KIRKLEES METROPOLITAN COUNCIL INVESTMENT & REGENERATION SERVICE

Reference No:	2024/62/93554/W
Site Address:	5, Norcross Avenue, Oakes, Huddersfield, HD3 4FP
Description:	Erection of two storey side and rear extension
Recommending Officer:	Molly Storer

HOUSEHOLDER DELEGATED REPORT

Application Number	2024/93554
Location	5, Norcross Avenue, Oakes, Huddersfield, HD3 4FP
Proposal	Erection of a two storey side and rear extension.
Publicity end date	14 th February 2025
Number of representations received	One – see representations section.
Kirklees Local Plan Allocation/Designation	Unallocated in the Kirklees Local Plan
Extension to Time (EoT)	Yes EoT Date: 20 th February 2025
Recommendation	Conditional Full Permission

3 Side Elevation 1
1 : 50

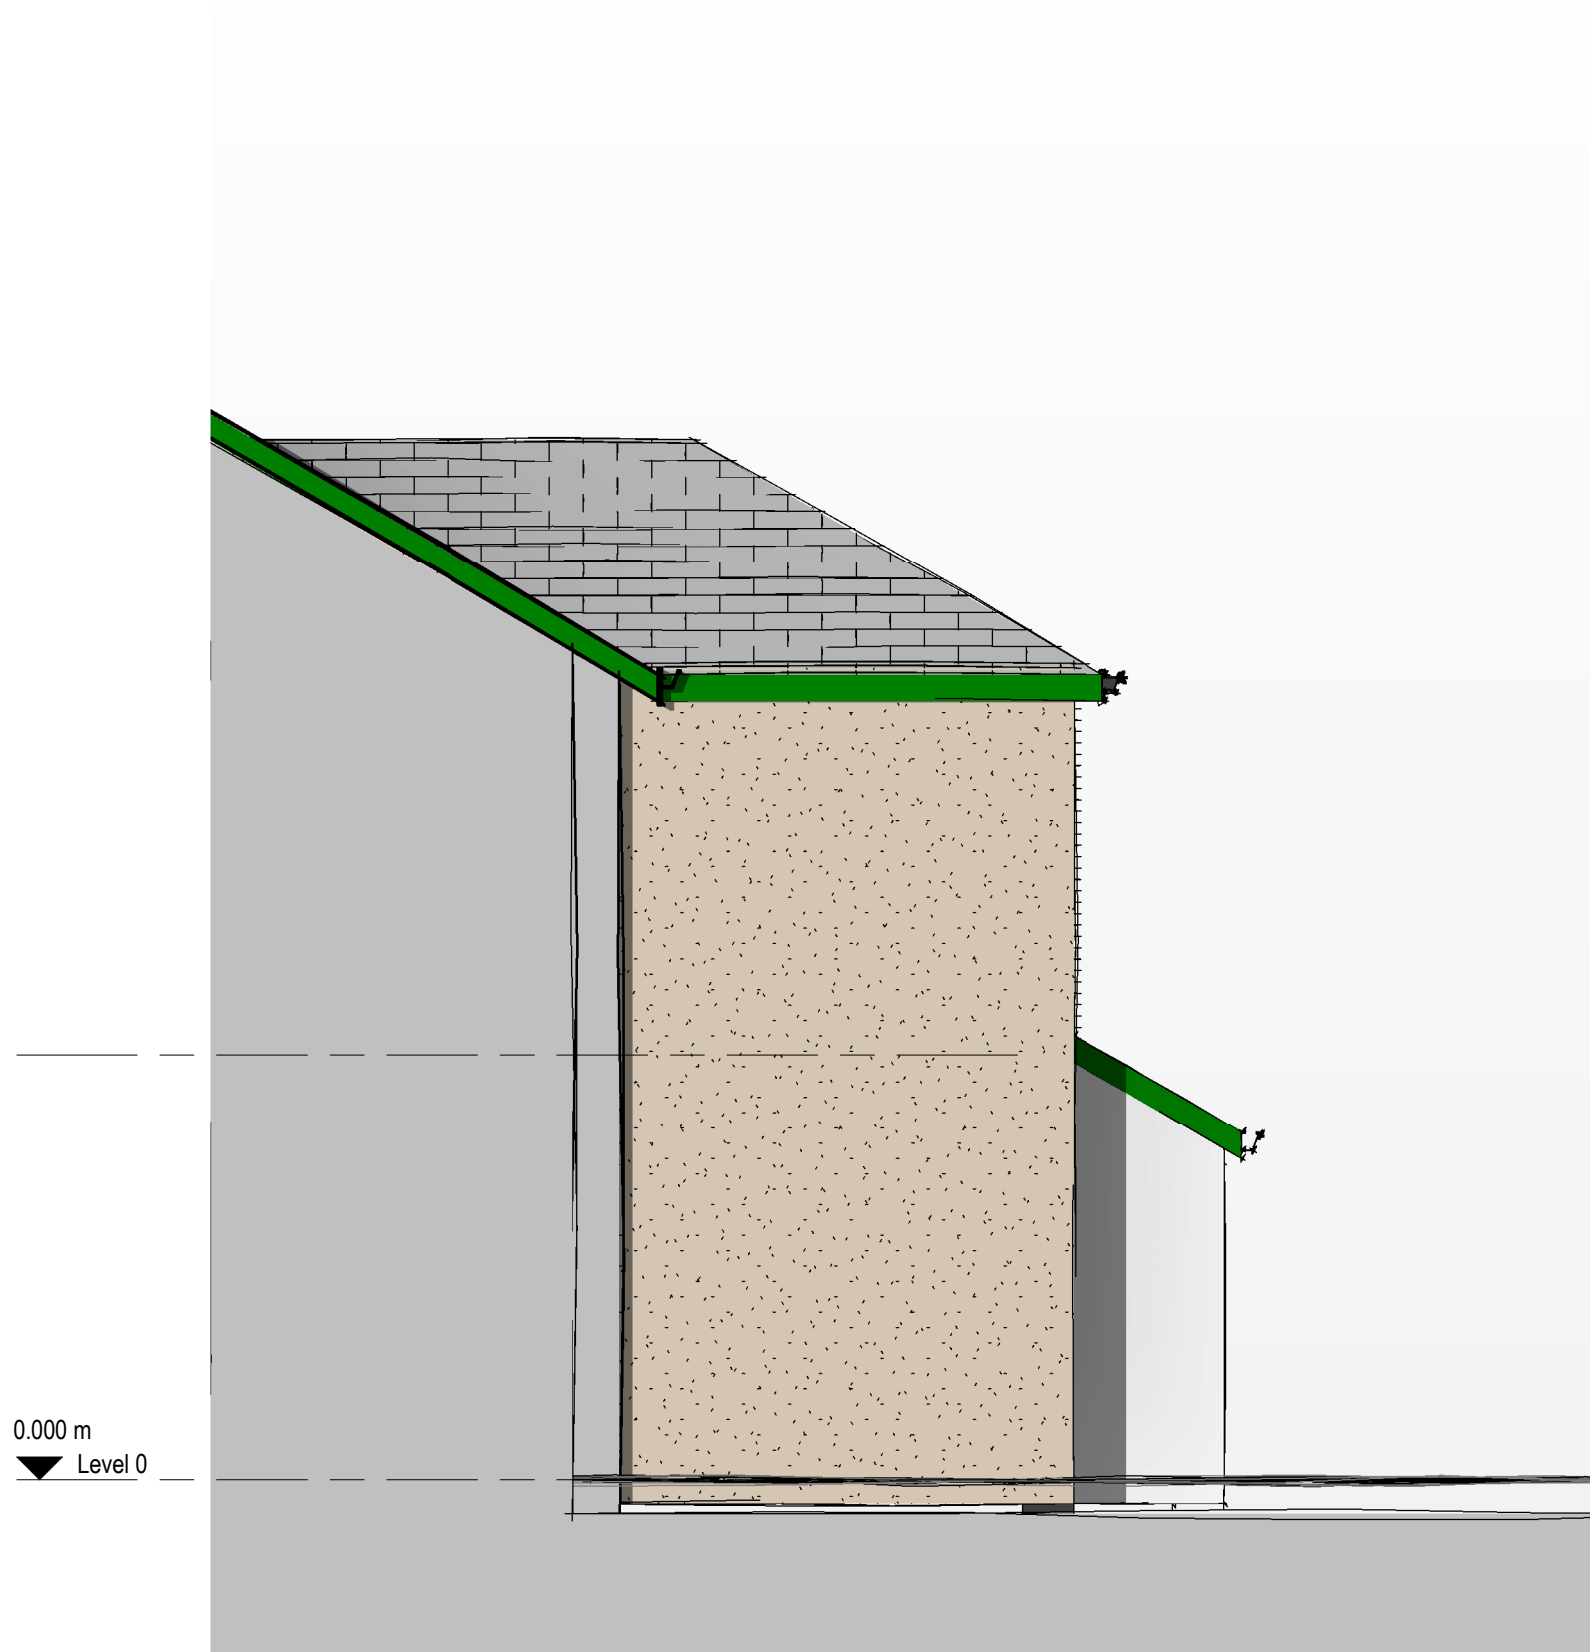
The scheme proposed in this application showed the first-floor element of the rear extension built on the boundary with No.7 whereas the amended plans for this application show the first floor element to be set off the boundary by 1m. The agent was contacted to show the 45-degree line from the extension to the nearest habitable room window at number 7 as the SPD states 'When assessing the impact of overshadowing on neighbouring properties, the council will, as a starting point, have regard to the 45° guidelines. A line will be drawn from the midpoint in the nearest habitable room window of the adjacent property, at an angle of 45°, across the proposed extension. The extent to which the line infringes upon the proposed extension will indicate the levels of light that may be lost to the neighbouring property.'

Submitted plans from the agent showed that the extension would have an effect on the 45-degree angle by 20cm to the neighbouring habitable room window and regard has to be had for this relationship. It is considered, on balance, that although the 45-degree angle is slightly impinged, due to the orientation of the properties as well as the extension being located to the north of No.7 the sun path is such that more light will be available to No.7. With regards to outlook this is an improved scheme than the refused scheme as space is afforded. Furthermore, there have been no objections received from number 7 in respect of the impact of the extension on their window therefore, given this and that the 45 degree line is only marginally cut in this isolated case this is considered acceptable.

The scheme proposed in this application showed multiple additional windows proposed to the side elevation facing number 3 in both the ground and first

floor. It also showed a two-storey element with a length of 6.7m at a separation distance of 0.75m. The plans for the current application show the majority of these windows to be removed and only a single window included to the side elevation which will be positioned to face onto a blank section of the neighbouring wall. It is also noted glazing which currently directly faces a habitable window at No.3 will be removed and replaced with a blank wall in this position, improving privacy. With regard to the length – part of the side extension has been reduced to single storey and the two storey element will have a length of only 3.3m and the separation distance has been increased to 1m. This is considered to overcome the previous reason for refusal as it is now considered that the extension will not be unduly overbearing and oppressive and would maintain a reasonable level of light to No.3.

This is considered to overcome the previous reason for refusal as it is now considered that No.7 will receive acceptable levels of light, and the extension will not be unduly overbearing or oppressive.

Drawing
Proposed Plans

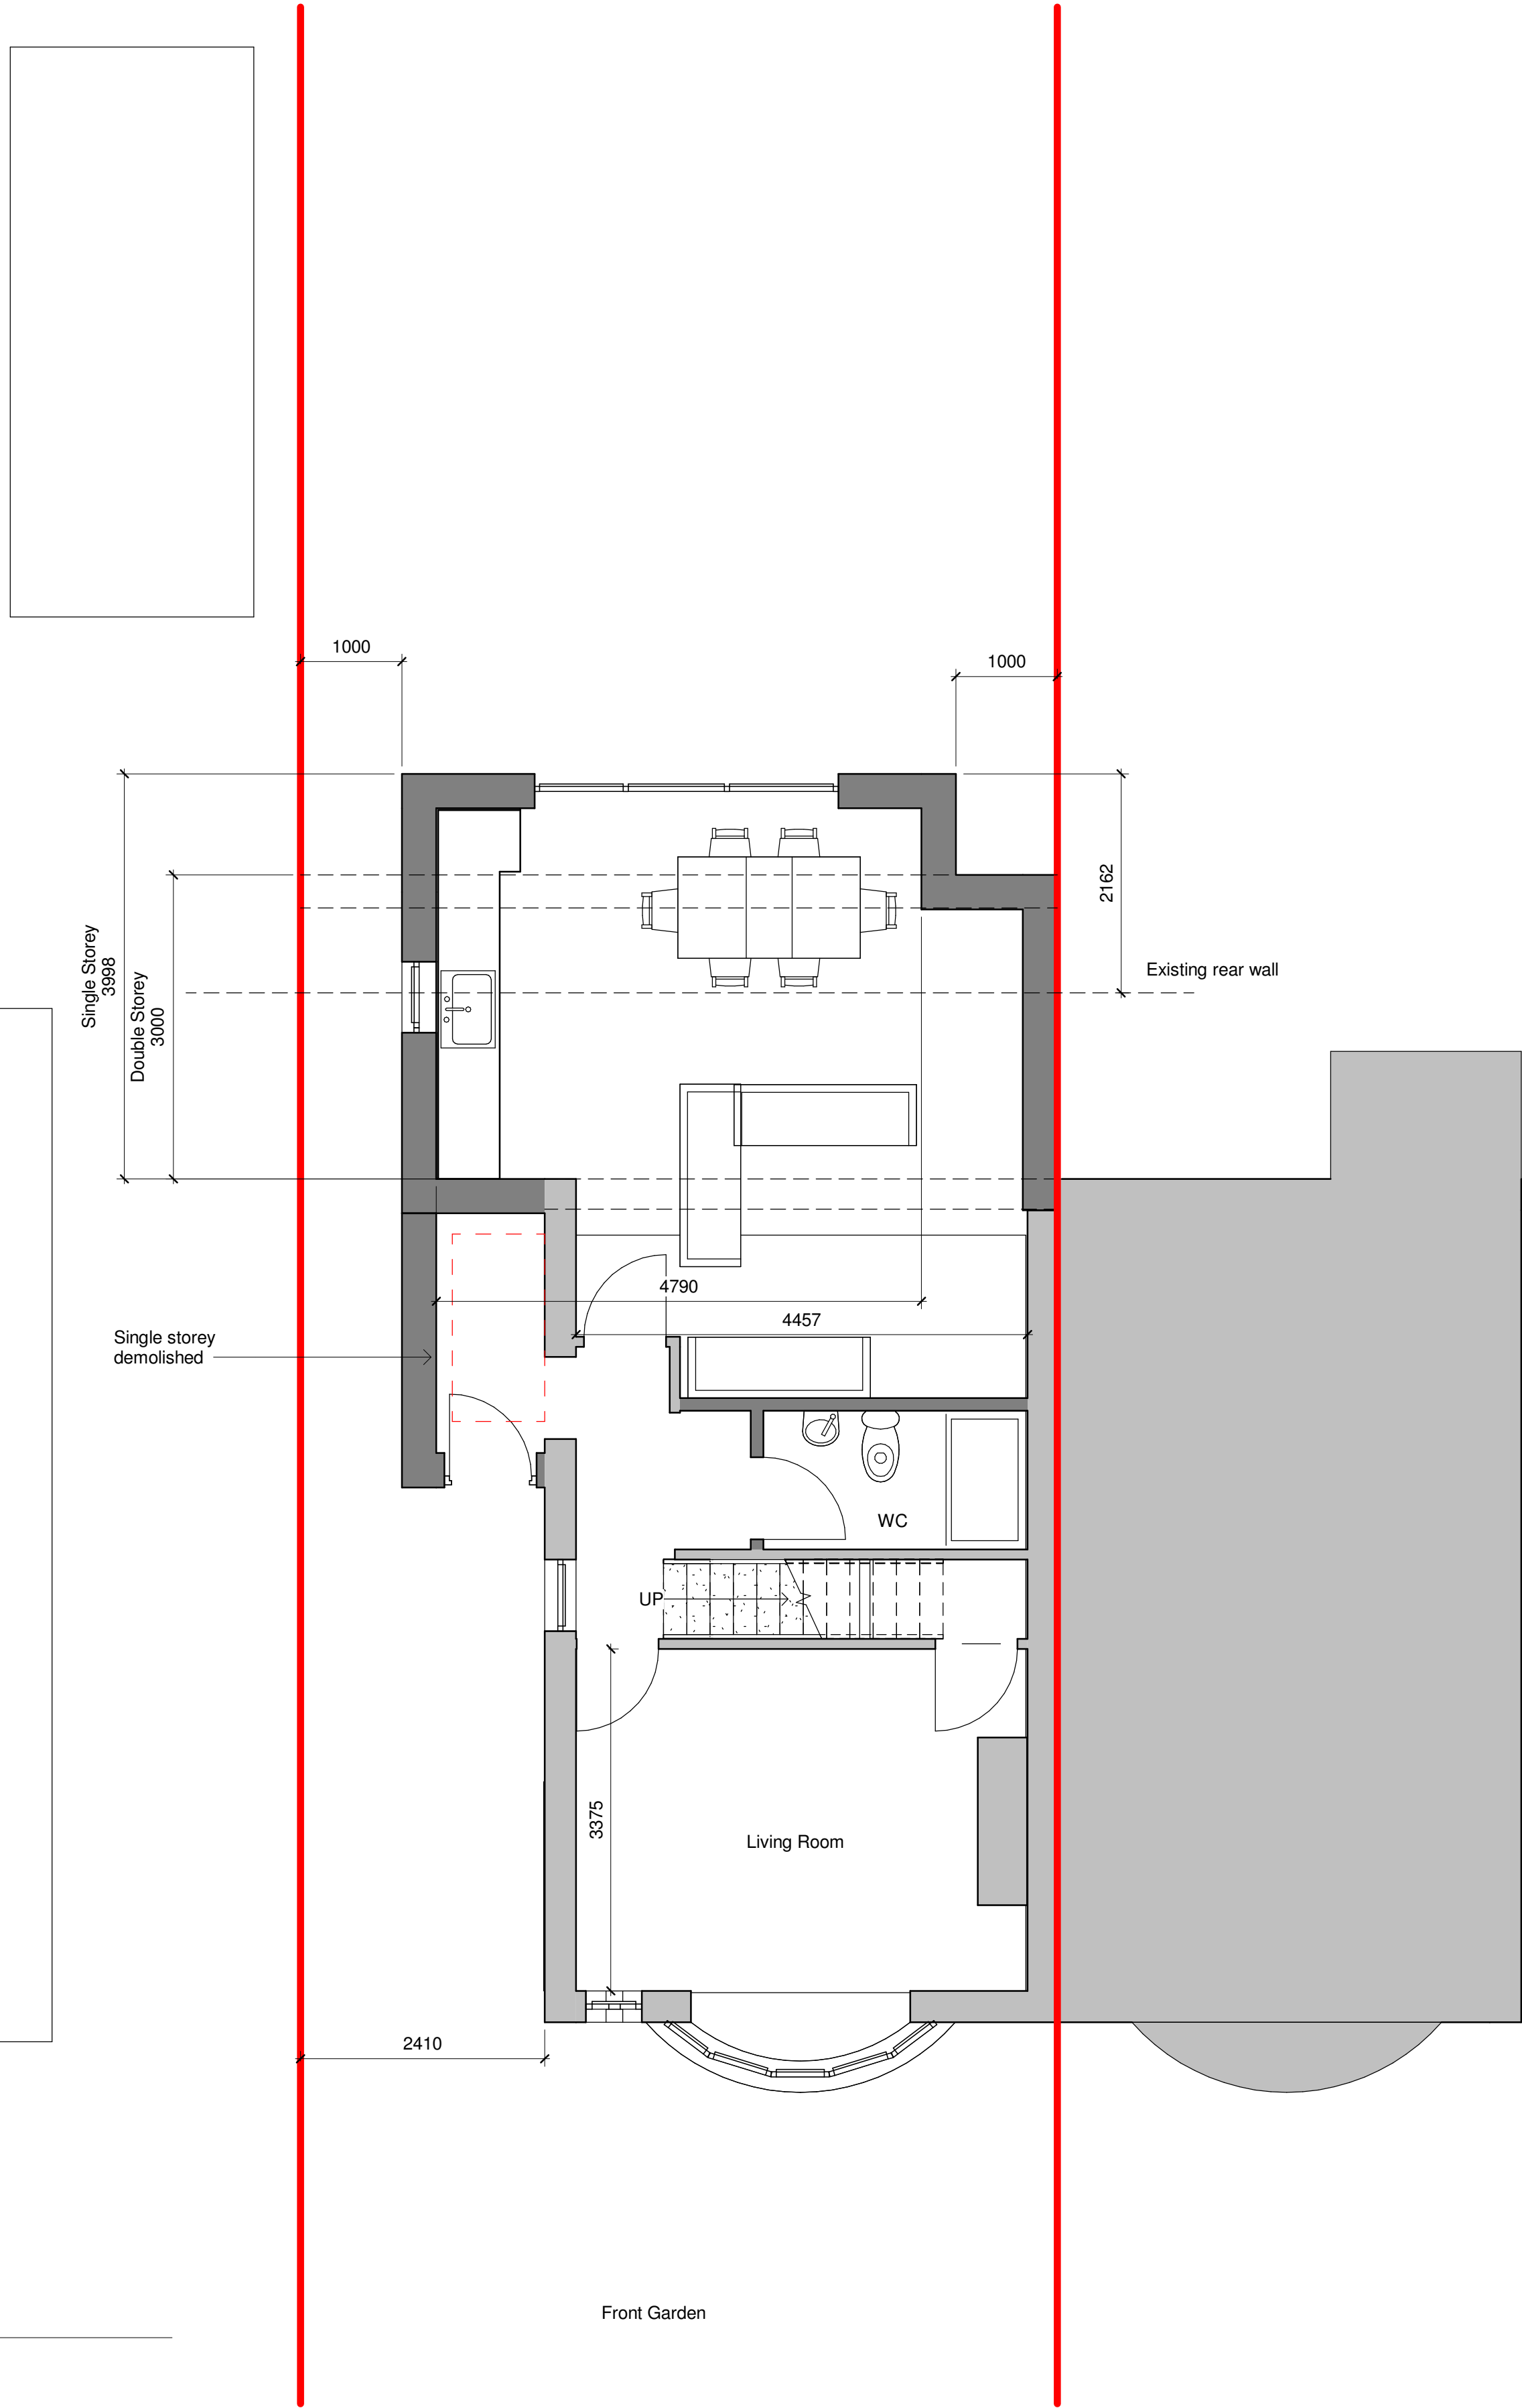
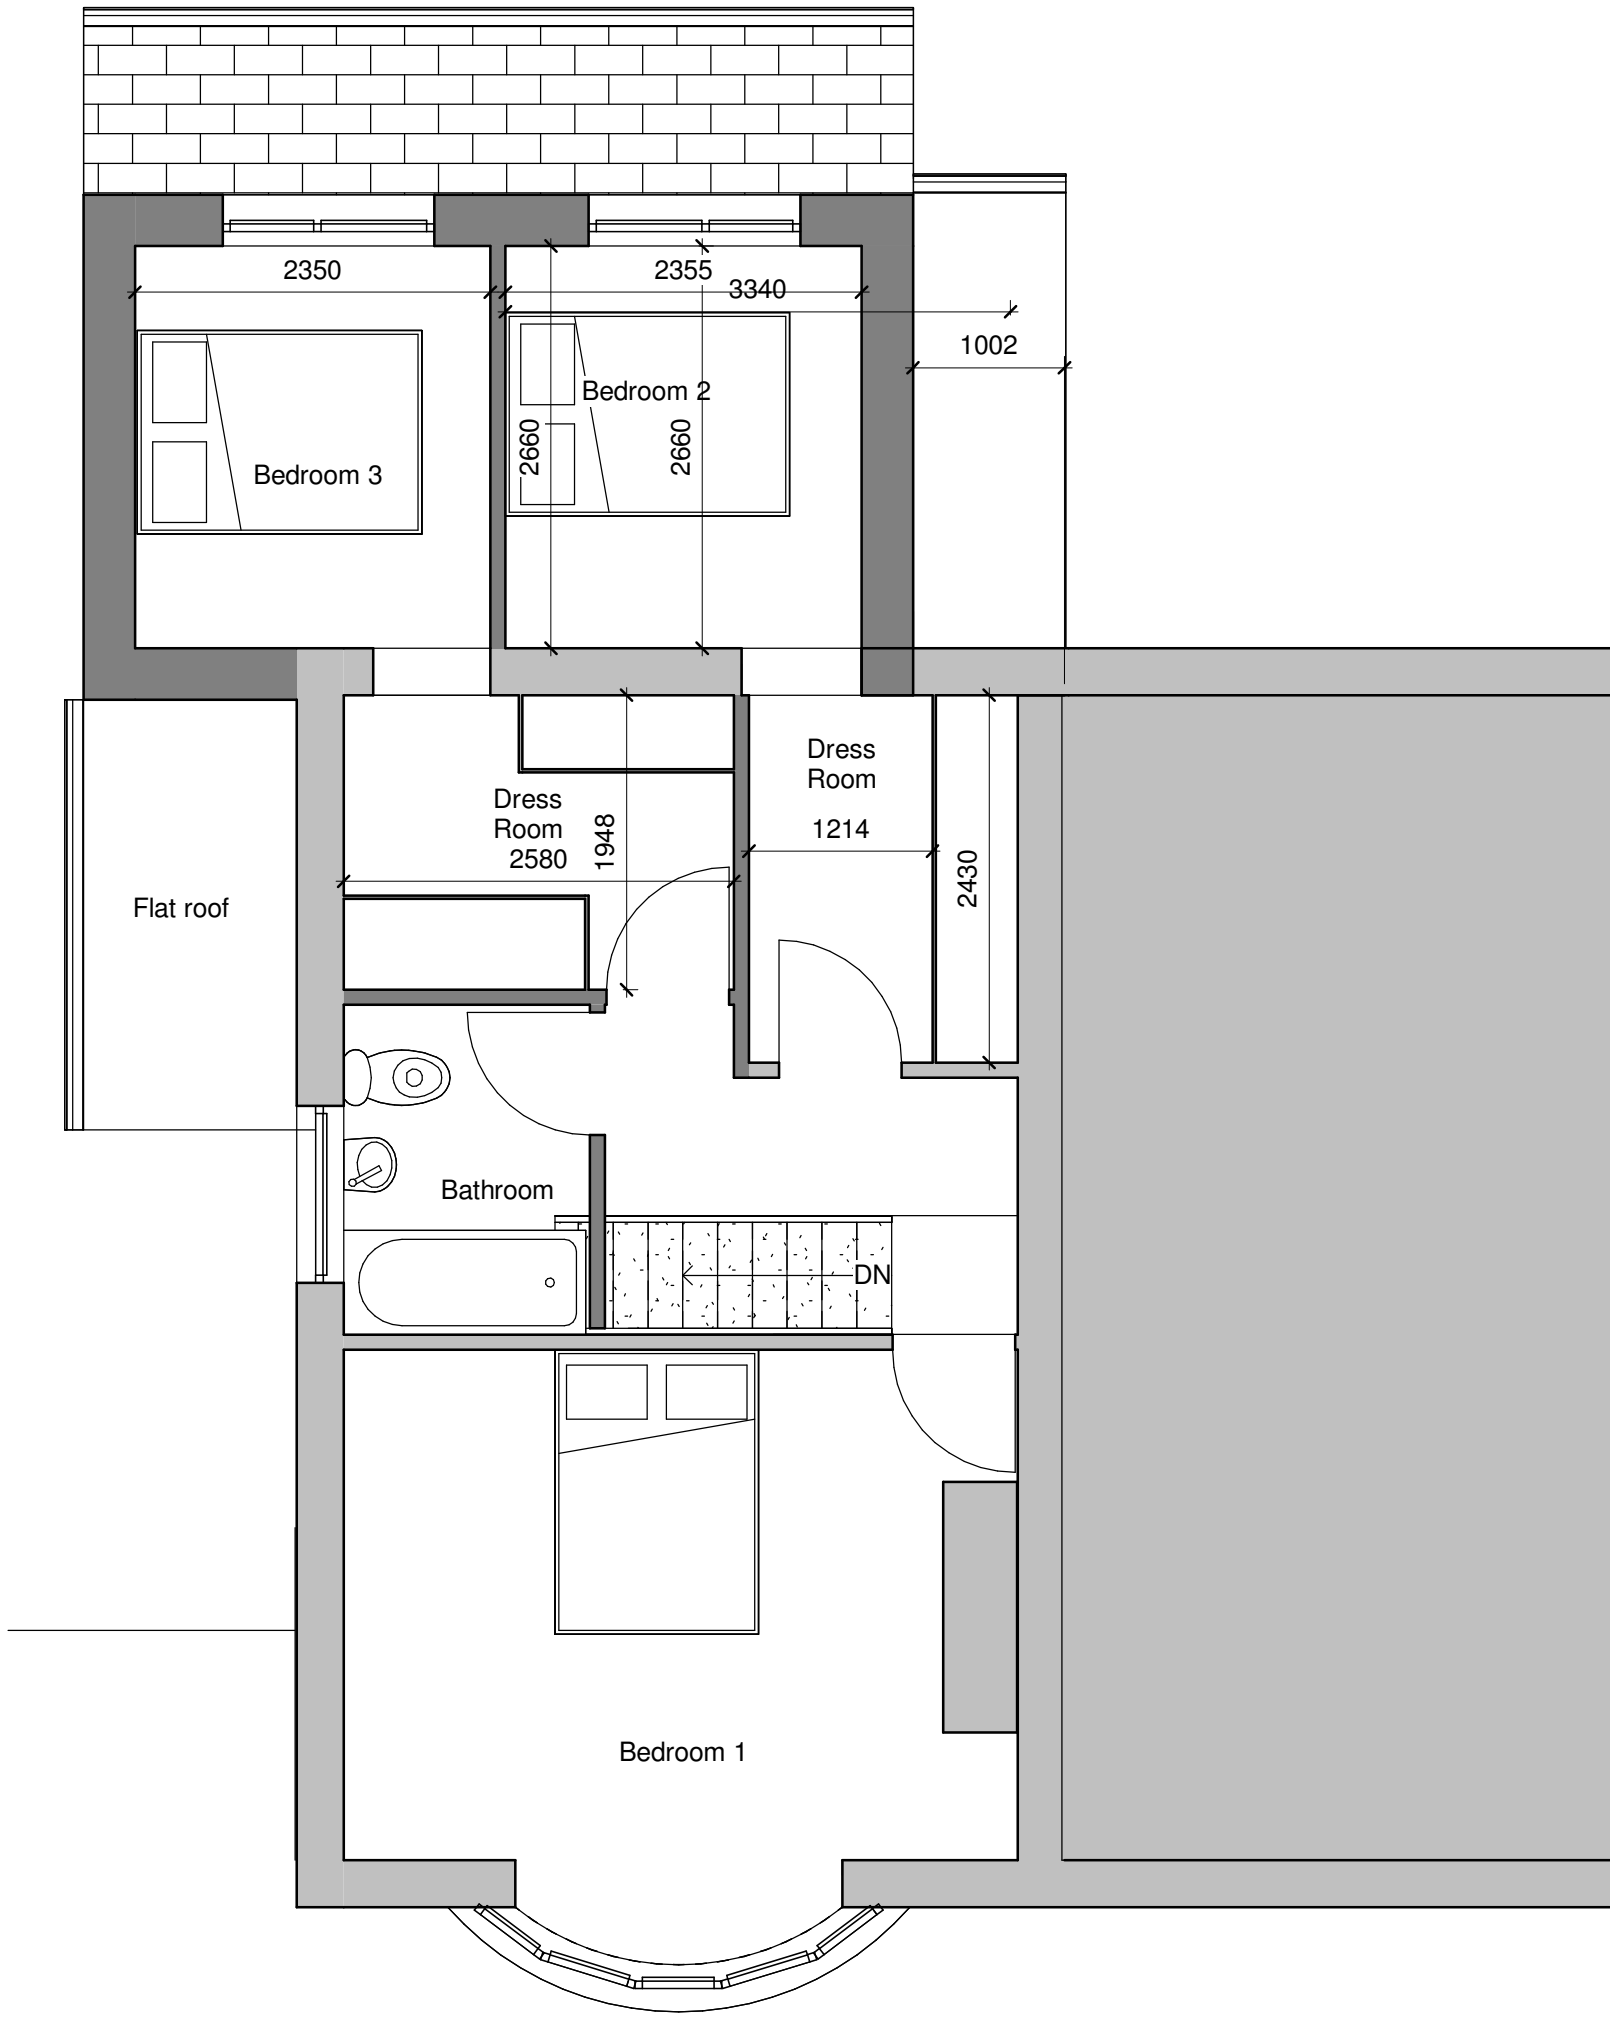
The application is for the erection of a two storey side and rear extensions. The plans show that the rear extension would project 3m at a two storey height and will be separated by a metre to the boundary with No.7. At a single storey height the extension would project a further metre and would be set along the boundary with No.7 for 3m and be set off the boundary by 1m for the last metre.

The two-storey rear element would have a width of 5.5m and would wrap around the side of the property, whereby the side extension would project 1.4m from the northeast (side) elevation. This side element would have a full length of 7m with 3.3m of this being at a two-storey height and the rest being at a single storey height.
